Rezoning Transportation Analysis

Petition Number: 2022-151

Date	Description
1-25-23	First Review (TM)
03-23-23	Second Review (TM)

DRAWING NUMBER:
RZ-1

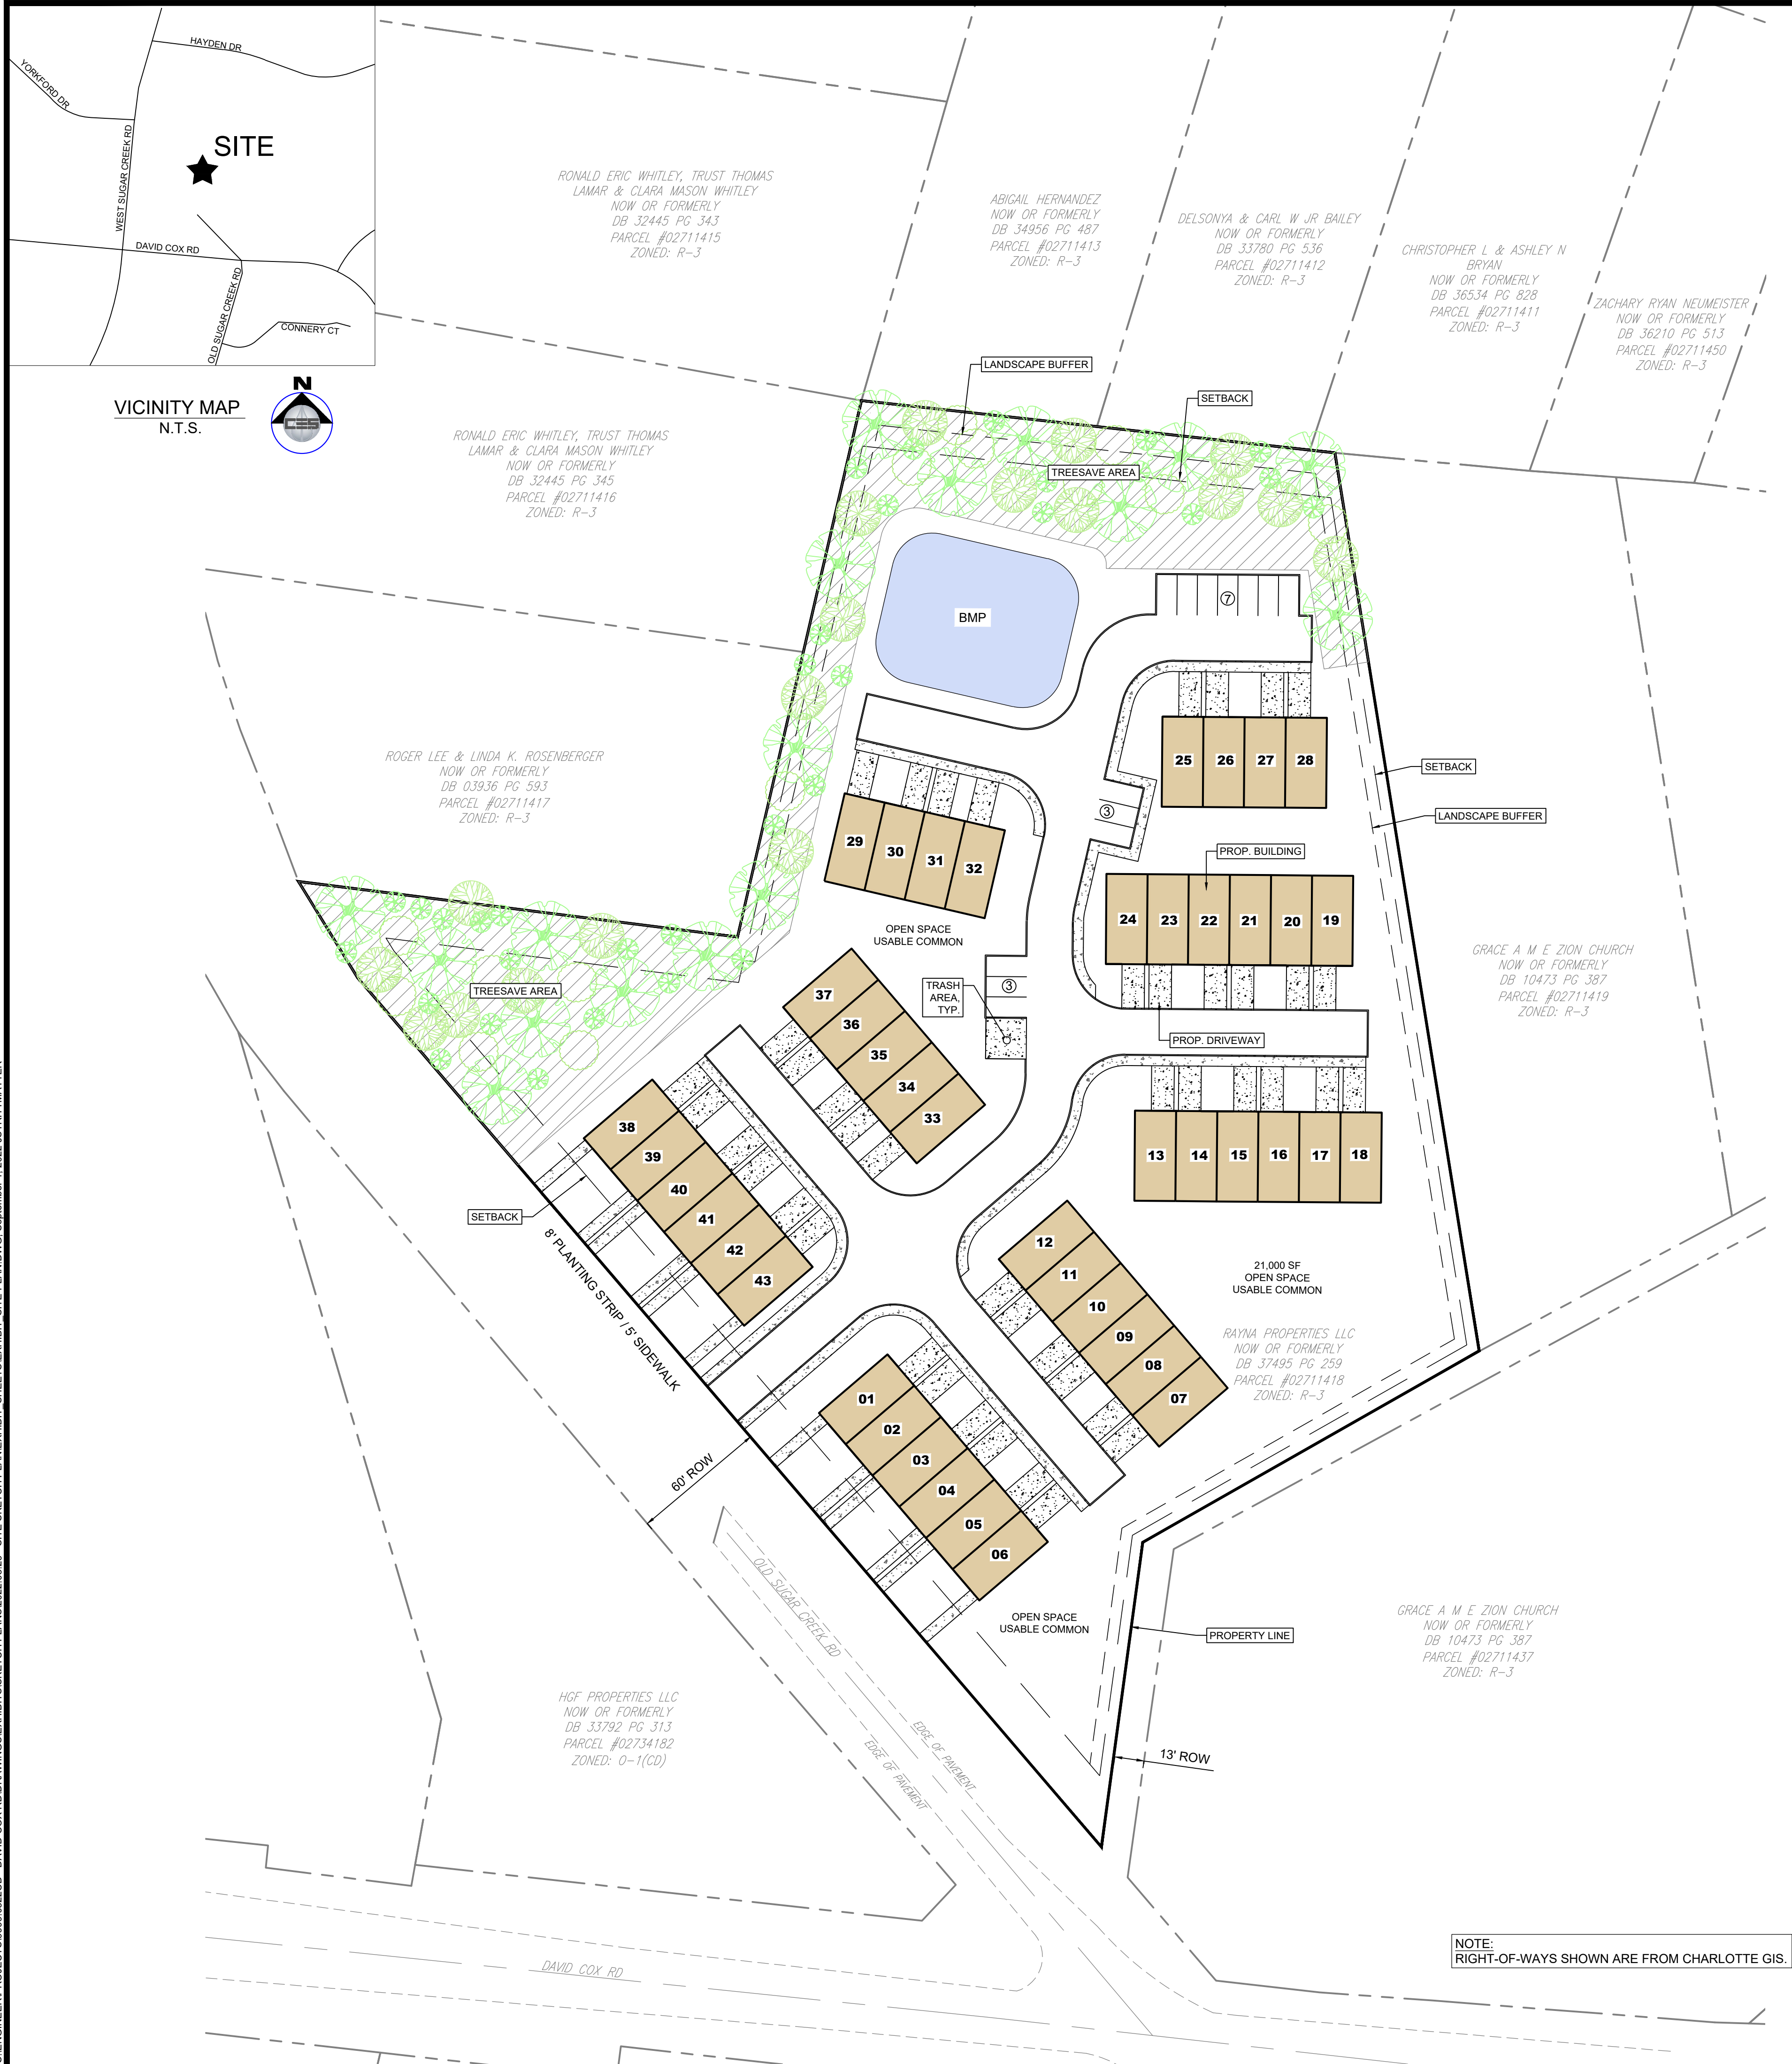
Outstanding comment from 01-25-23: Label and dimension the curb and gutter from the centerline for each road on the site plan.

- Outstanding comment from 01-25-23:** Revise site plan and conditional note(s) to commit to construct an 8-foot planting strip, and 6-foot sidewalk on newly constructed road per Chapter 19. The site plan shall label and dimension both items from the back of curb and gutter or edge of pavement.

Clarifying Comment 03-23-23: Revise site plan by labeling the proposed public street extension per CLDSM U-02, dimension back of curb from roadway centerline and add dimensions of sidewalk on site plan.

10. **NEW COMMENT 03-23-23:** Revise site plan by labeling all internal proposed streets as private.
